## A303 Amesbury to Berwick Down

TR010025

**8.34 –The Applicant’s Comments on the Positions Adopted at Deadline 4 by Wiltshire Council and the Trail Riders Fellowship in Respect of Proposed Changes to the Order in Relation to Byways 11 and 12**

July 2019

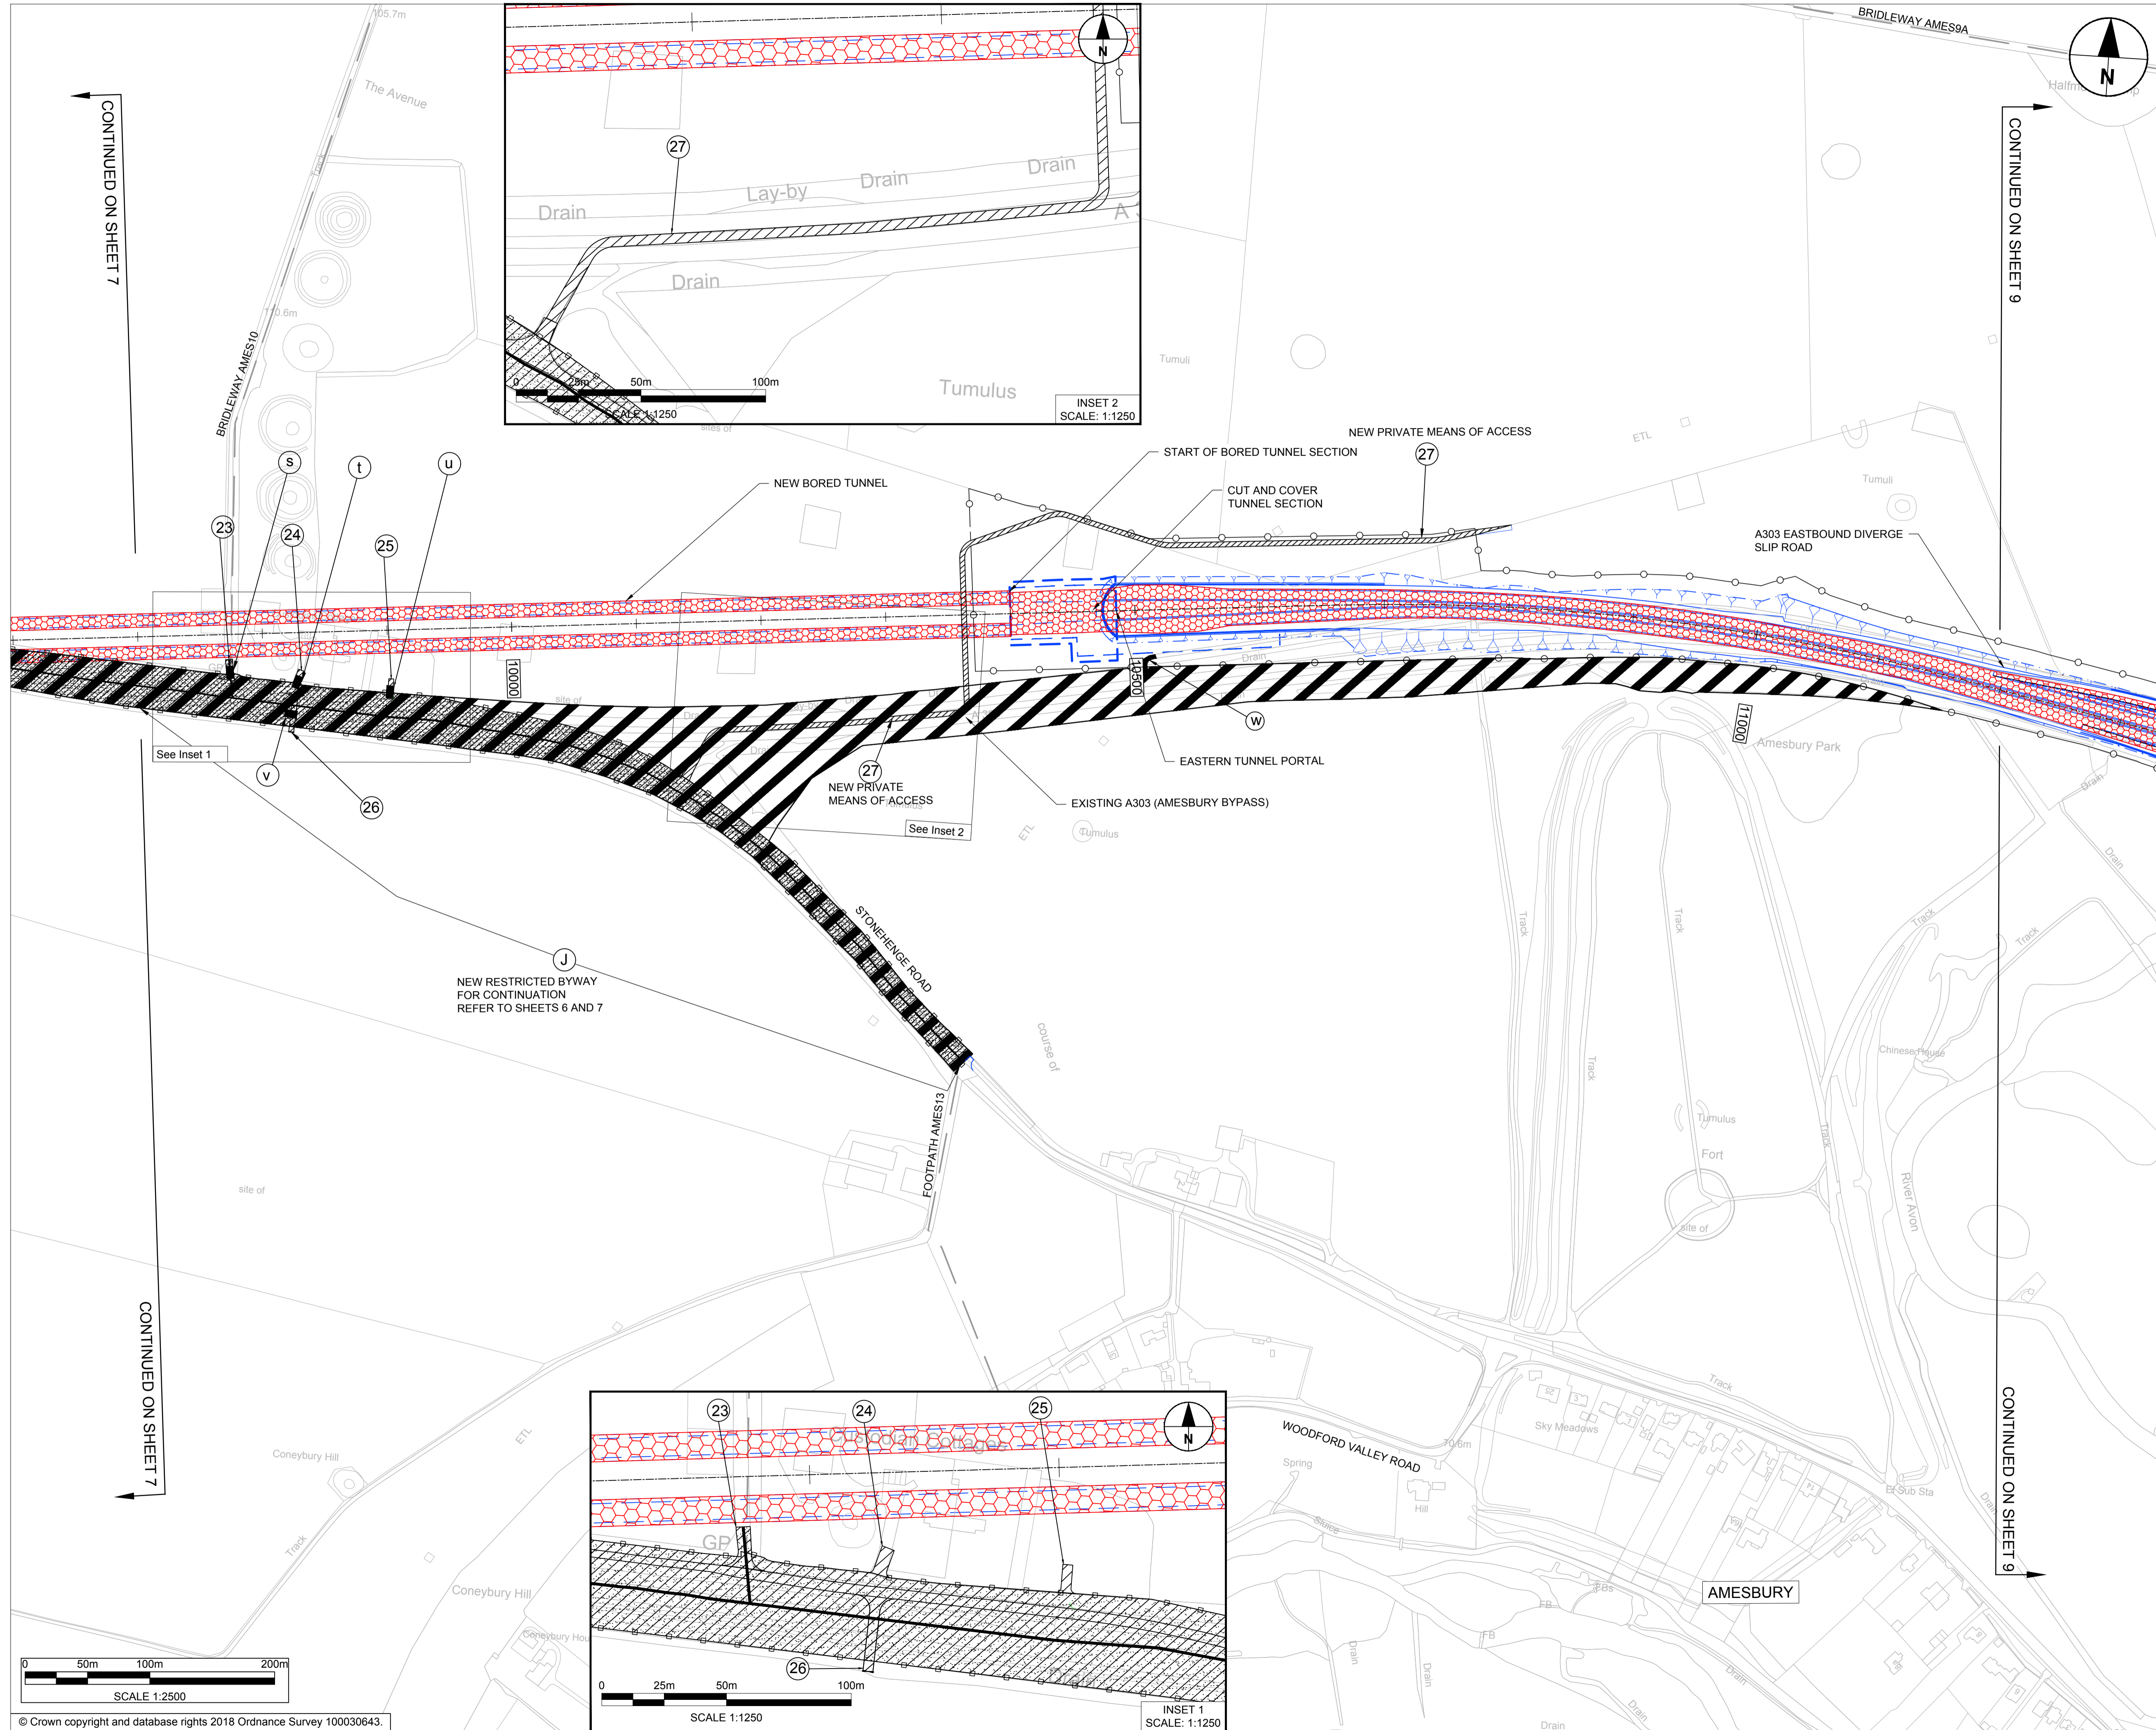
- 4.4 It is important to note that the Applicant's draft DCO would not authorise the stopping up of public rights of vehicular access over any part of byway AMES 11. This is clear from the absence of any entry in Schedule 3. The "zebra hatching" on sheet 7 of the Rights of Way and Access Plans in the vicinity of the junction of the existing A303 with the northern end of AMES11 is constrained to being within the highway boundary of the existing A303. The solid black bar, labelled reference "p", relates to the stopping up of a private means of access (see Part 3 of Schedule 3) and not public highway. Consequently, no deletion of the stopping up of public vehicular access of the northern end of AMES11 is necessary.
